DECISION DELEGATED TO HEAD OF PLANNING

Application No: H11-0128-23 **Applicant:** Tears of Sutton Bridge

Proposal: Demolition of existing commercial buildings and erection of new office, admin buildings and workshops (B2) to accommodate the relocation of Tears Recovery

Location: Land To Rear Of 45-47 Bridge Road Long Sutton Spalding

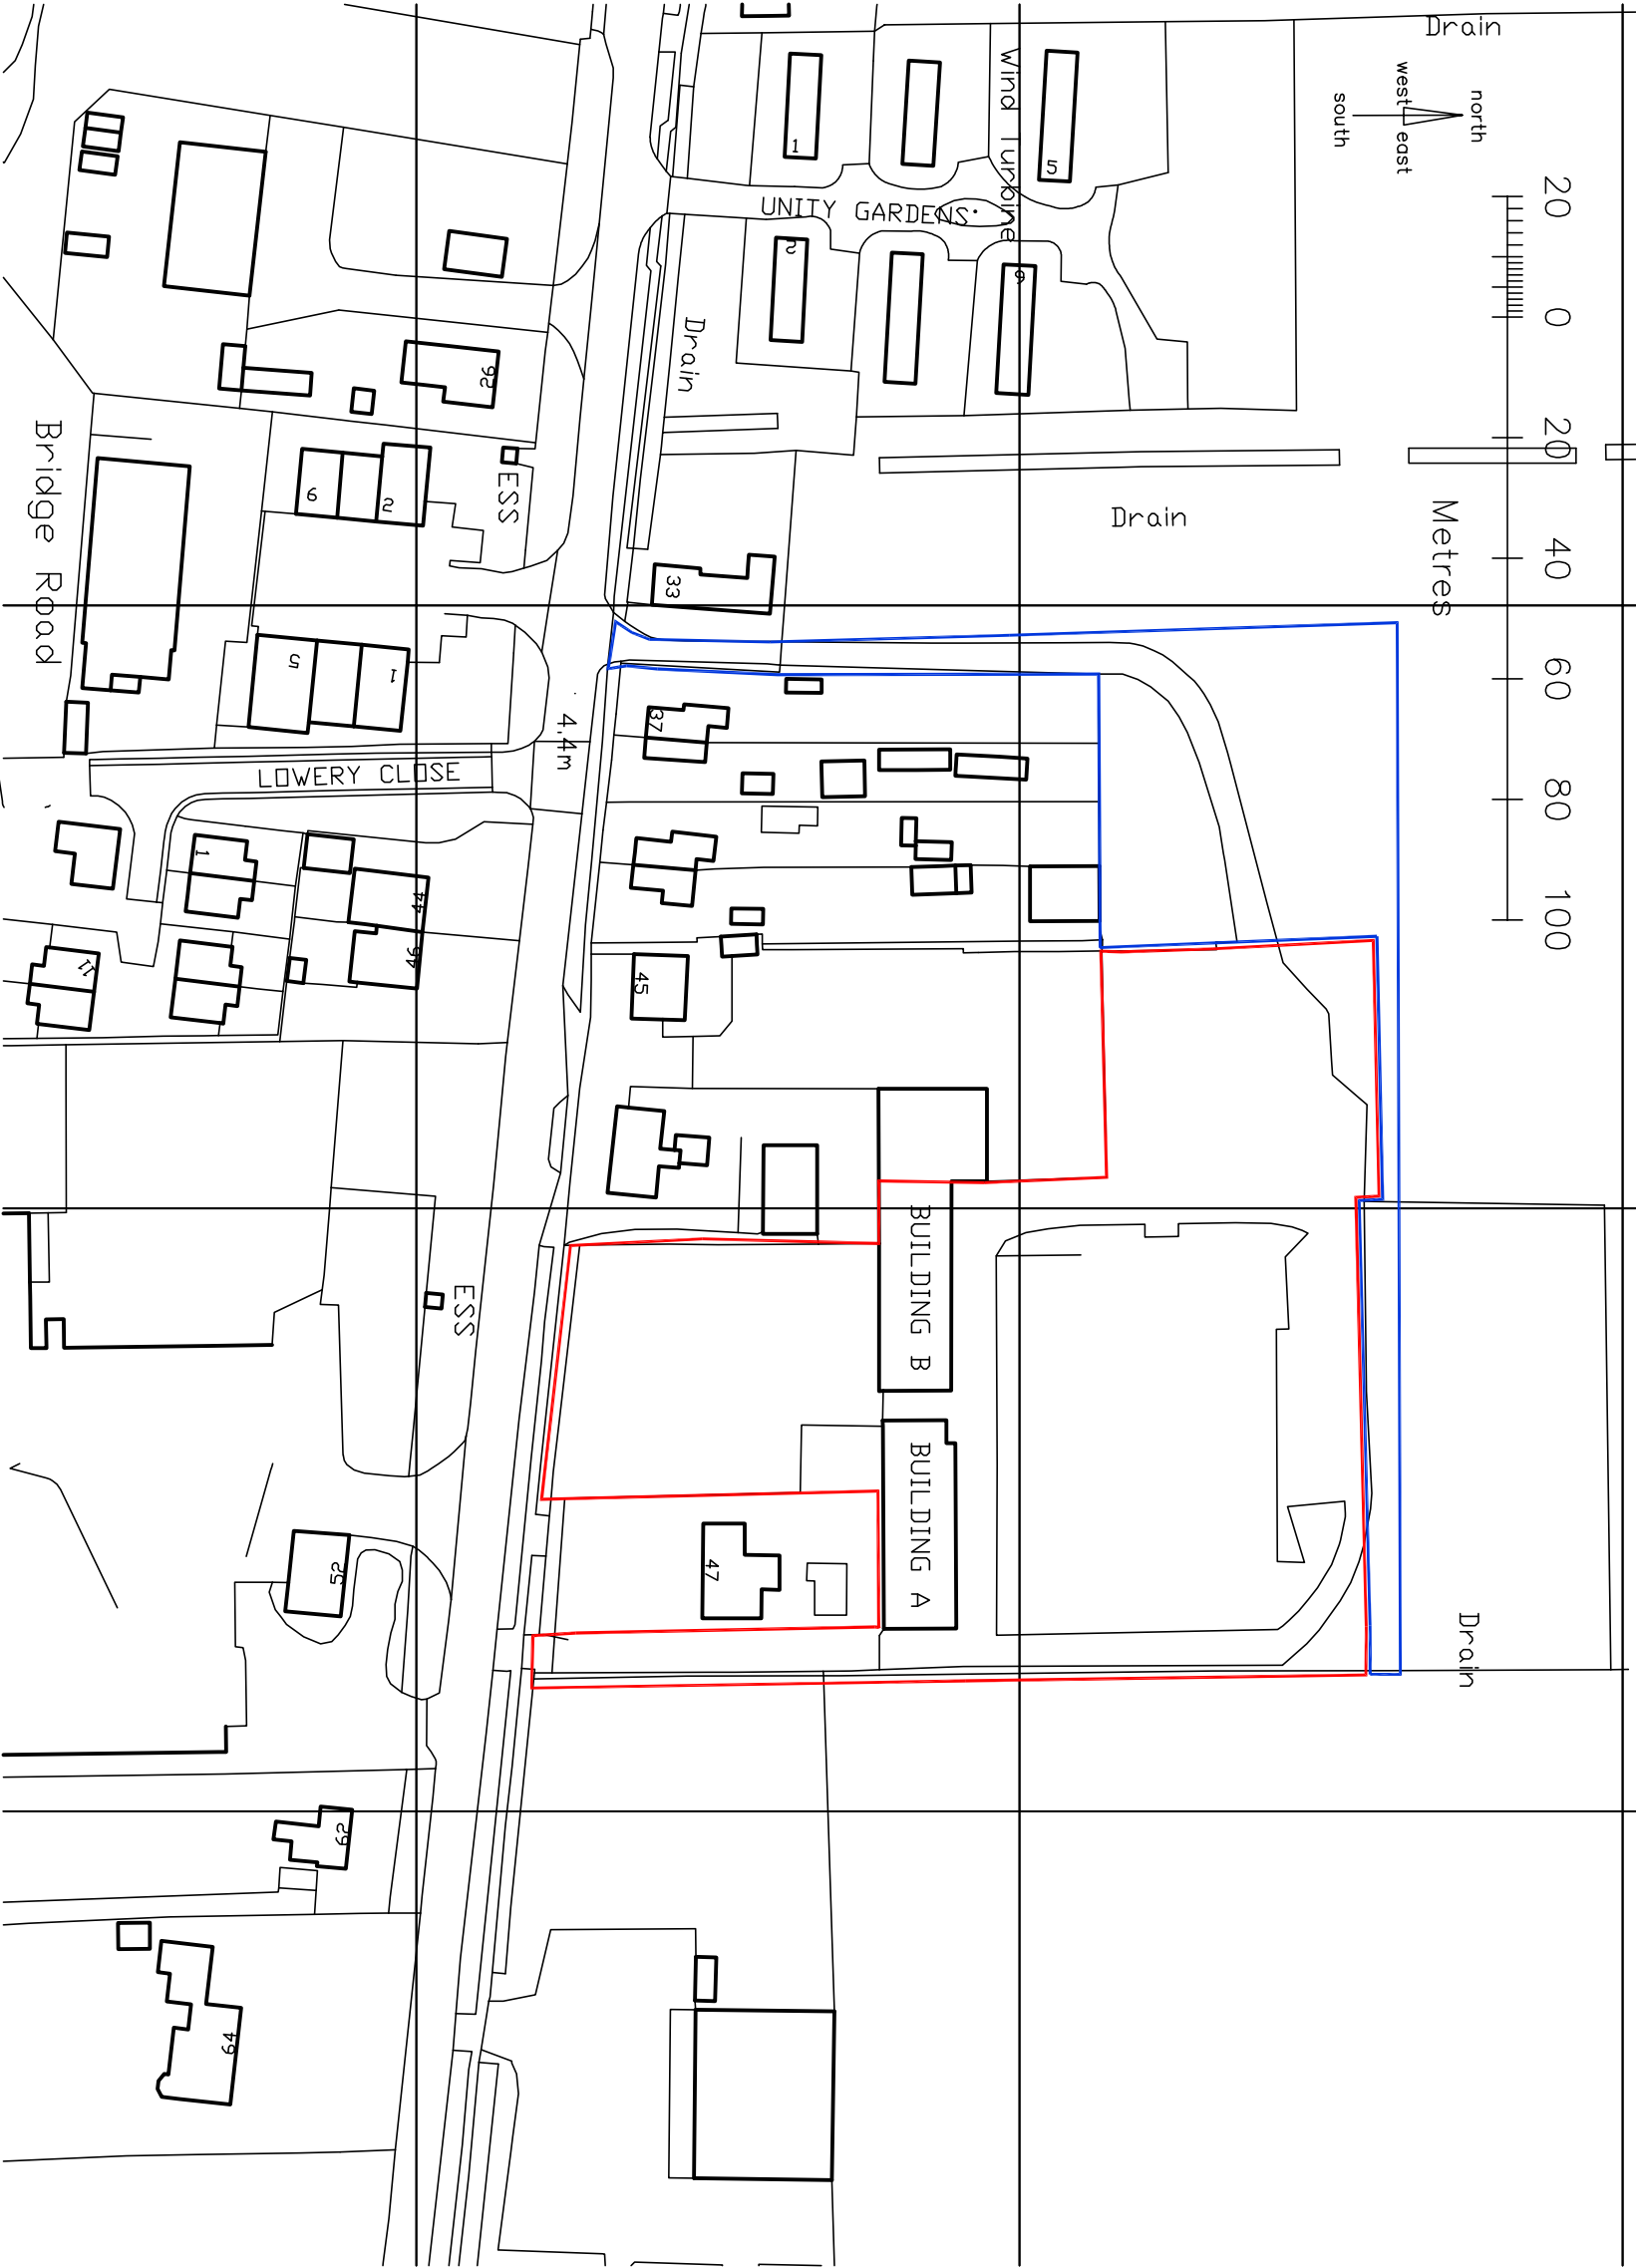
I note the presence of a Board Maintained watercourse (DRN201G4301 - K43 Main Road - West) adjacent to the southern site boundary and that works are proposed to alter this watercourse including construction of a new access road over the watercourse (drawing ref: 448SK02, I-Lid

Design, 10th December 2021). To enable this proposal consent is required under Section 23 of the Land Drainage Act 1991 (and byelaw 4) and I recommend that the applicant contacts this office to make an application for this consent at their earliest convenience.

I note that the applicant intends to install an access road and planting within 9 metres of the aforementioned Board Maintained watercourse (drawing number 448SK02 REV D, Proposed Tears Recovery Site, i-lid, 10/12/2021). To enable this proposal, consent would be required under Byelaw 10, and I recommend that the applicant contacts this office to make an application for this consent at their earliest convenience. To avoid conflict between the planning process and the Board's regulatory regime, we recommend that the required consent is sought prior to the determination of this planning application.

D	13/03/23	FLOOR LEVEL IN OFFICE RAISED FOR FRA
C	17/01/23	DETAILS AMENDED
B	31/10/22	DETAILS AMENDED
A	07/01/22	DETAILS AMENDED
Rev	Date	Detail

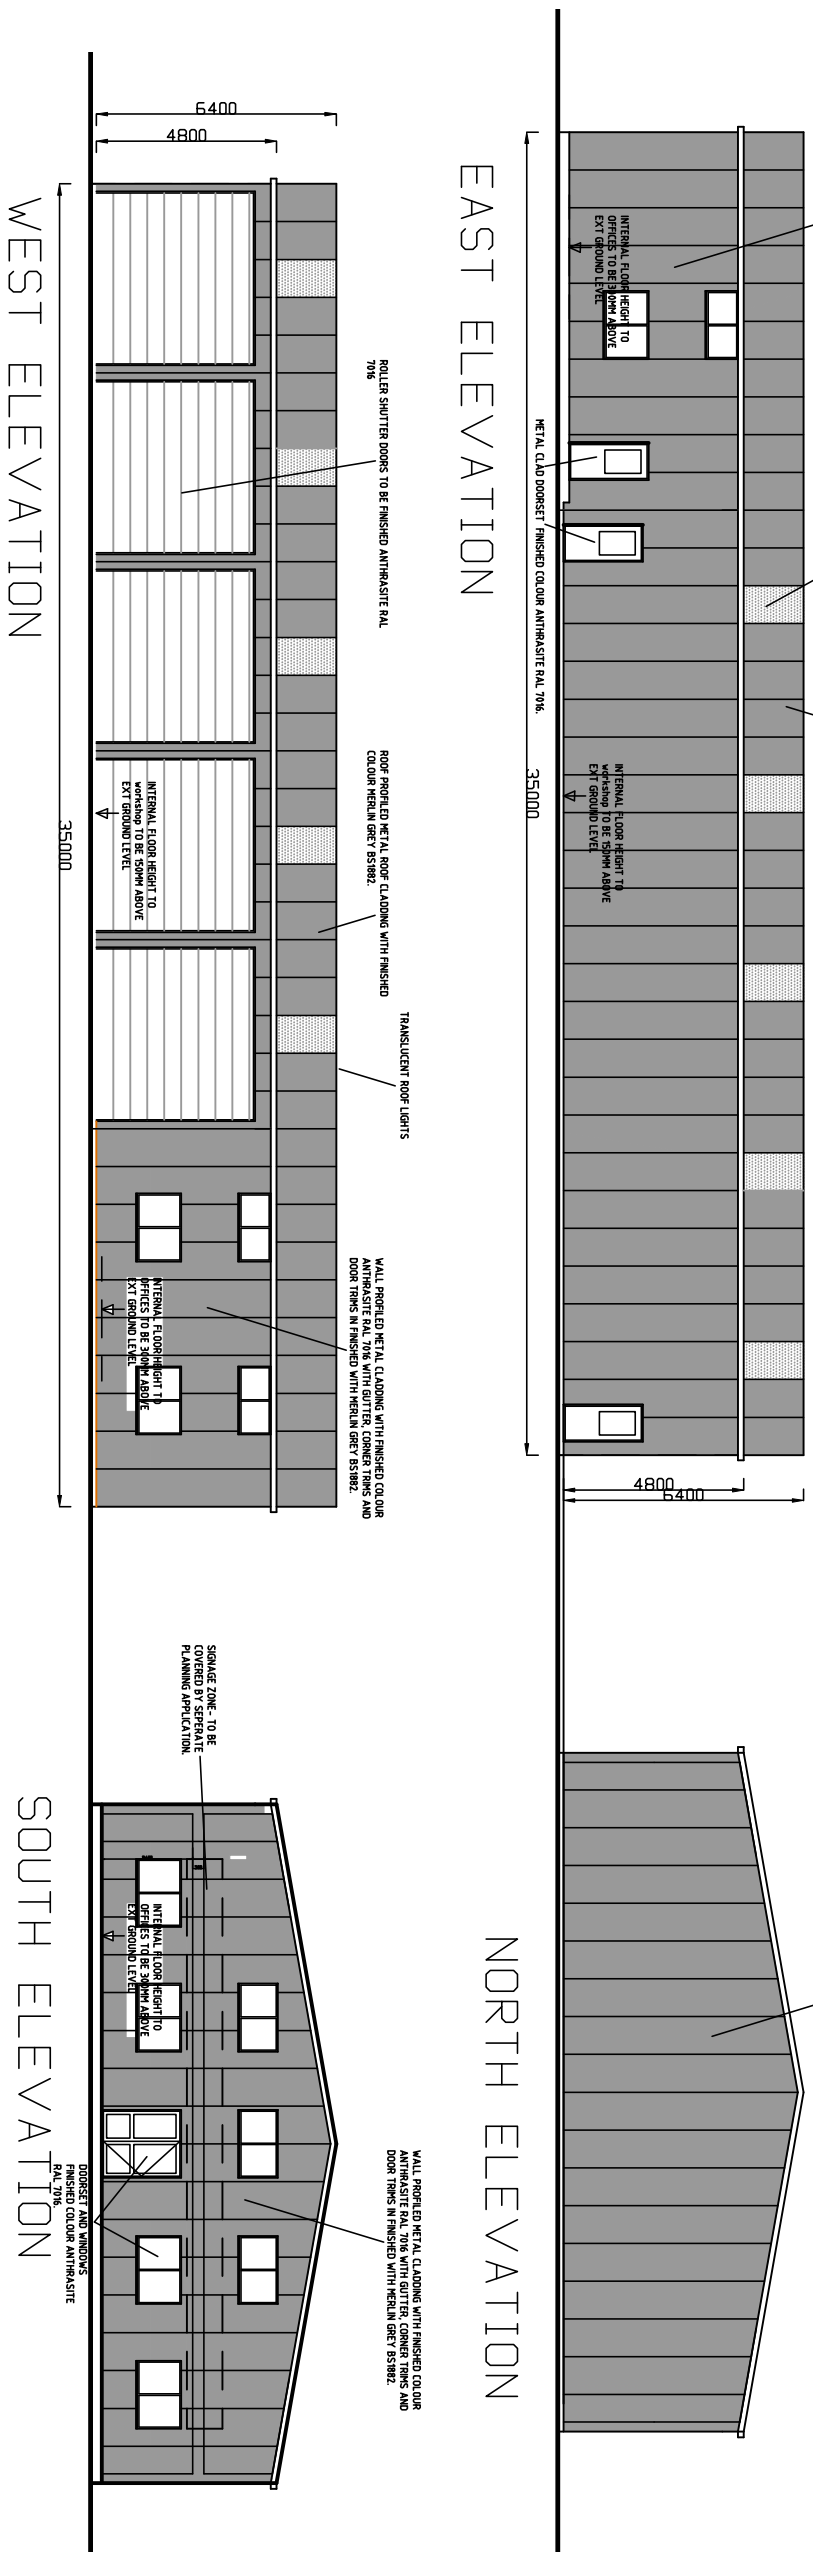
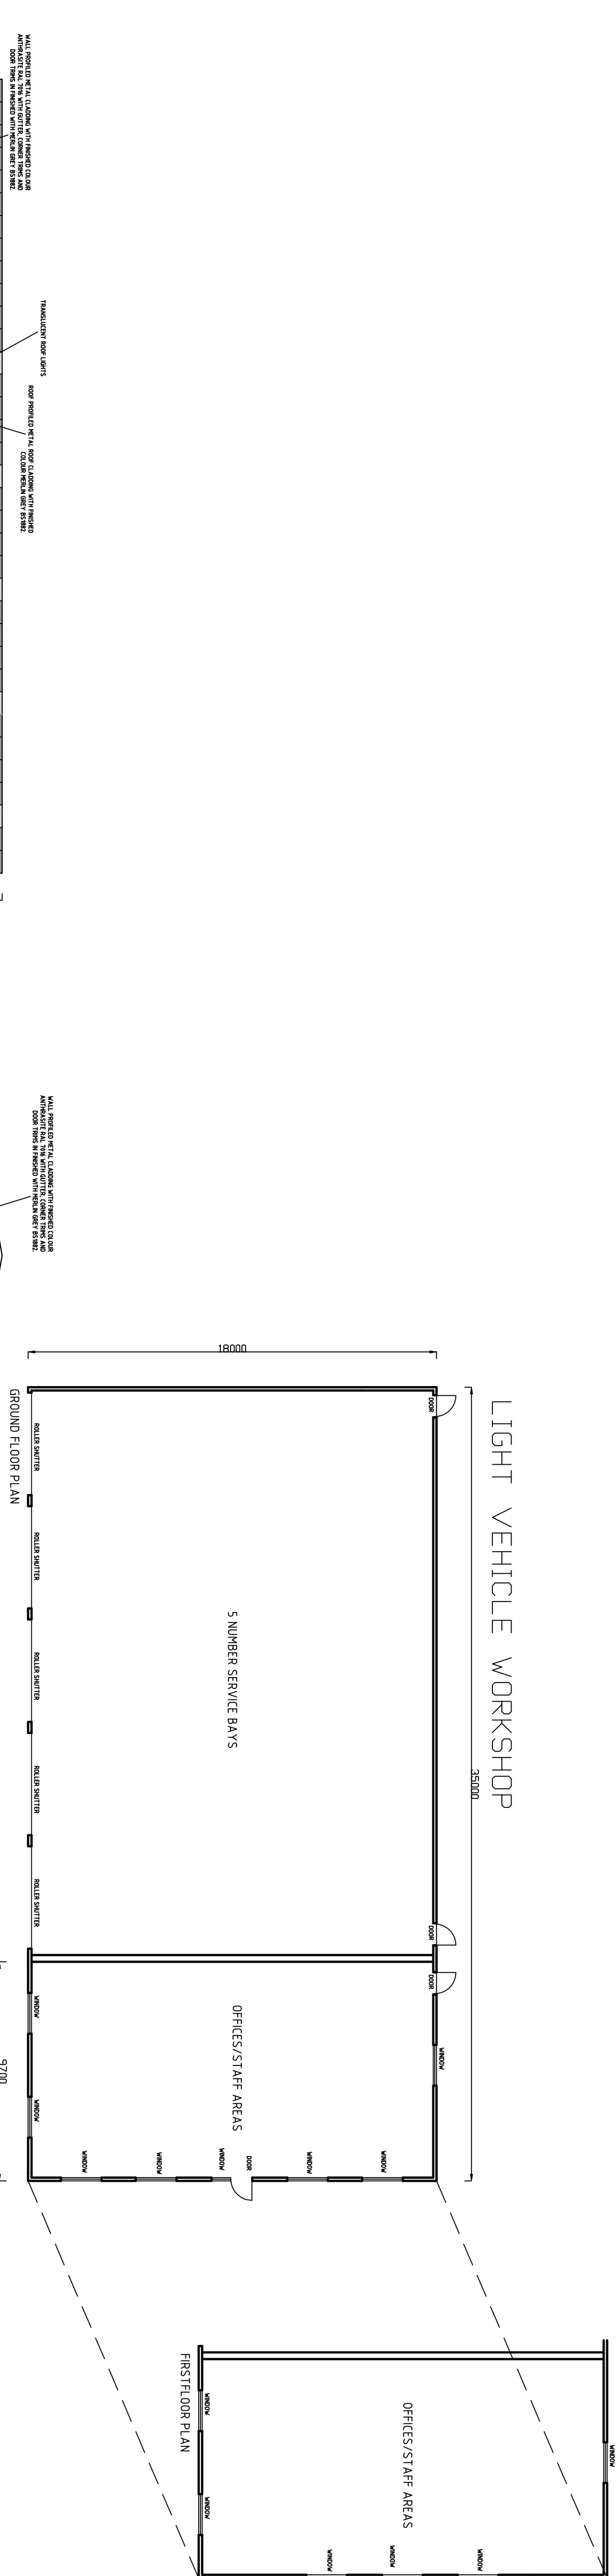
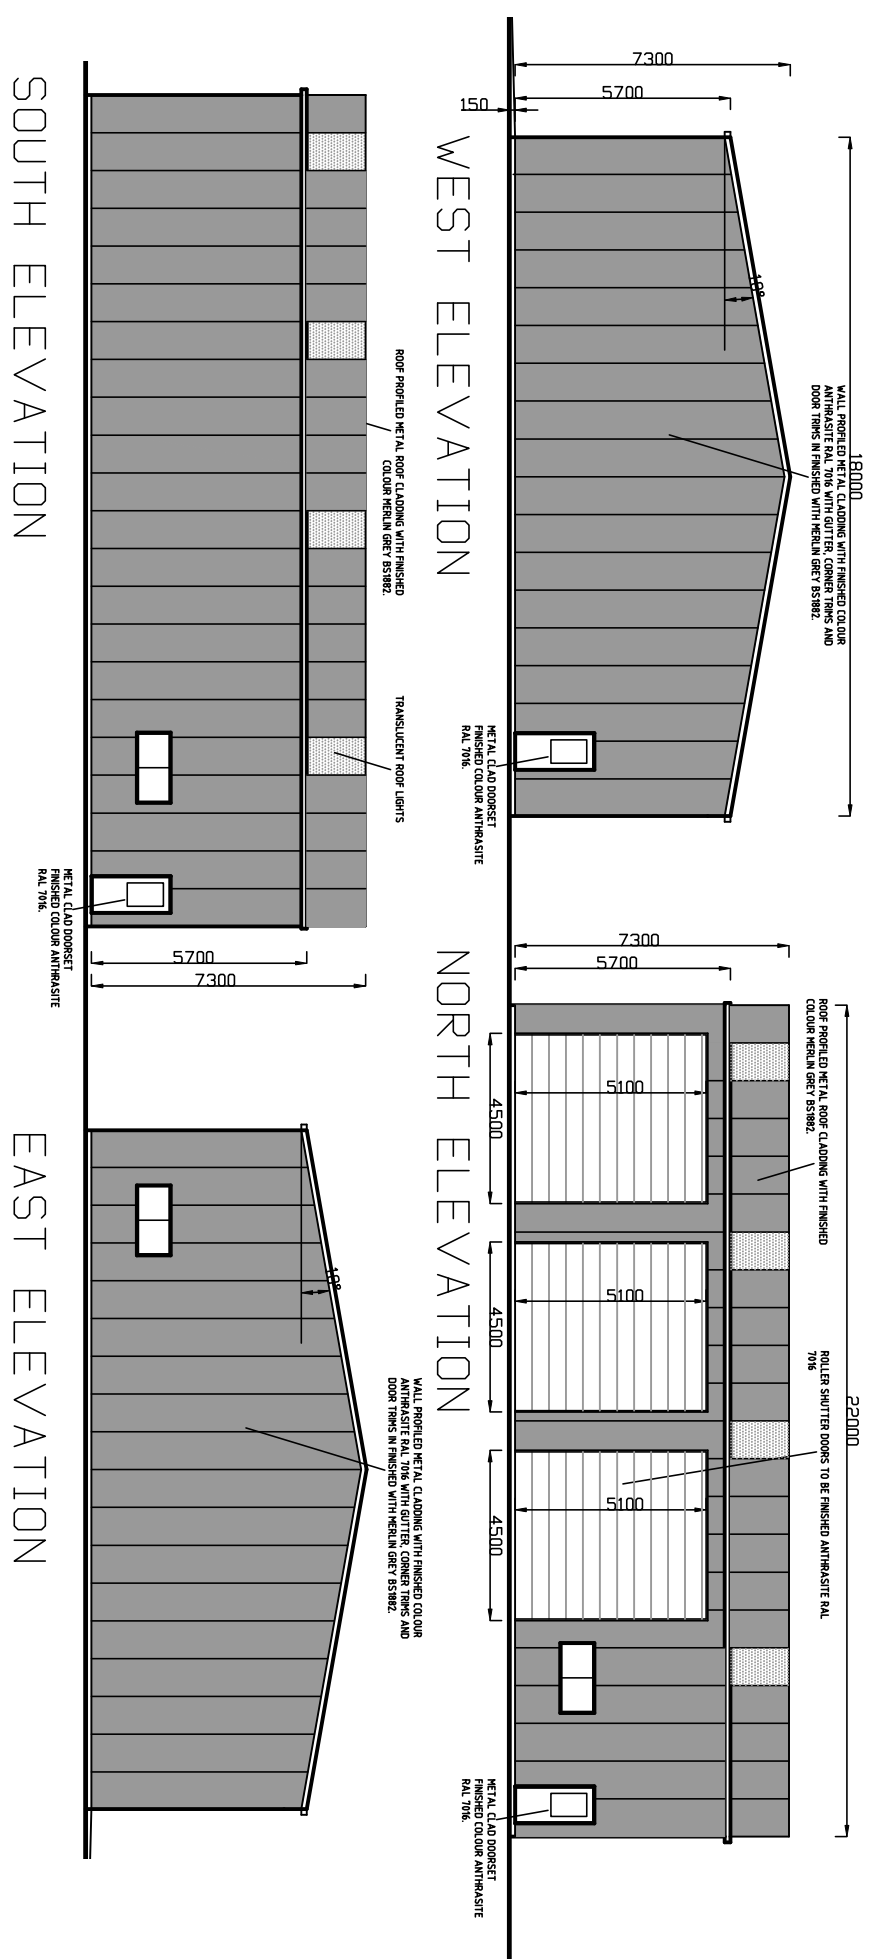
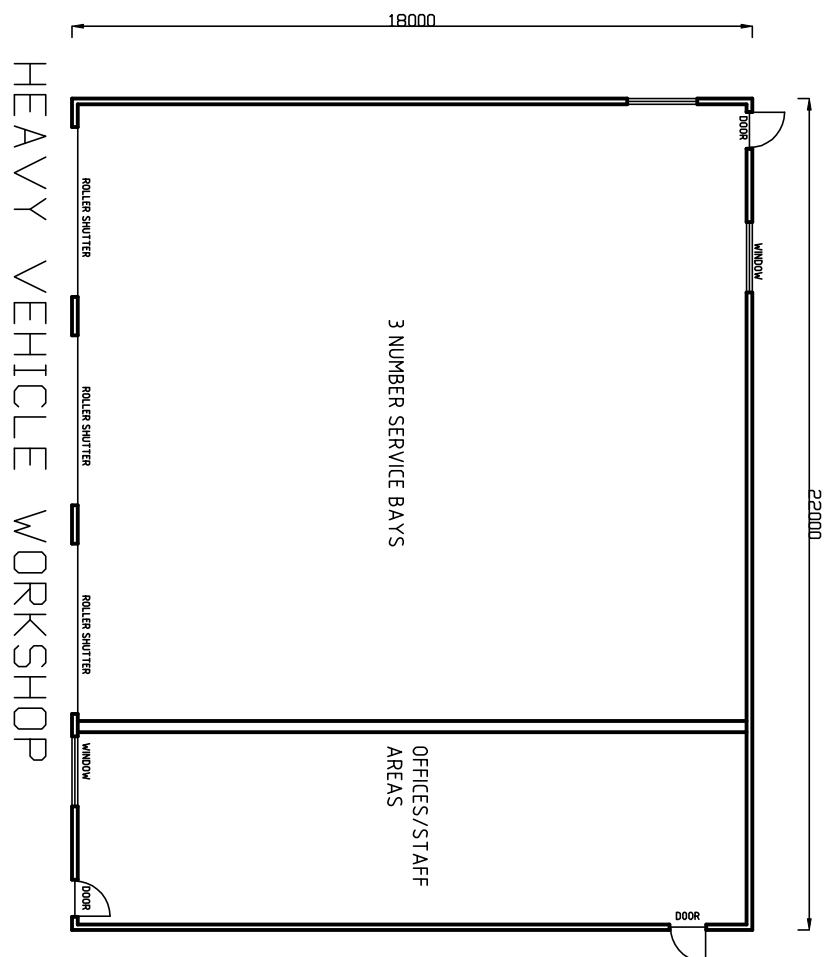
The amended drawing 'proposed building elevations/plans' (Drawing number: 448SK03, Revision D) shows the finished floor levels for the ground floor offices for the light vehicle workshop will be 300mm above the existing ground level we can therefore remove our previous objection dated 08 March 2023.

We note that the single storey heavy vehicle workshop does not have finished floor levels above the predicated flood depth, therefore you must be satisfied that the residual risk can be adequately managed through either a flood warning and evacuation plan or other appropriate measures, in accordance with your local flood risk standing advice.
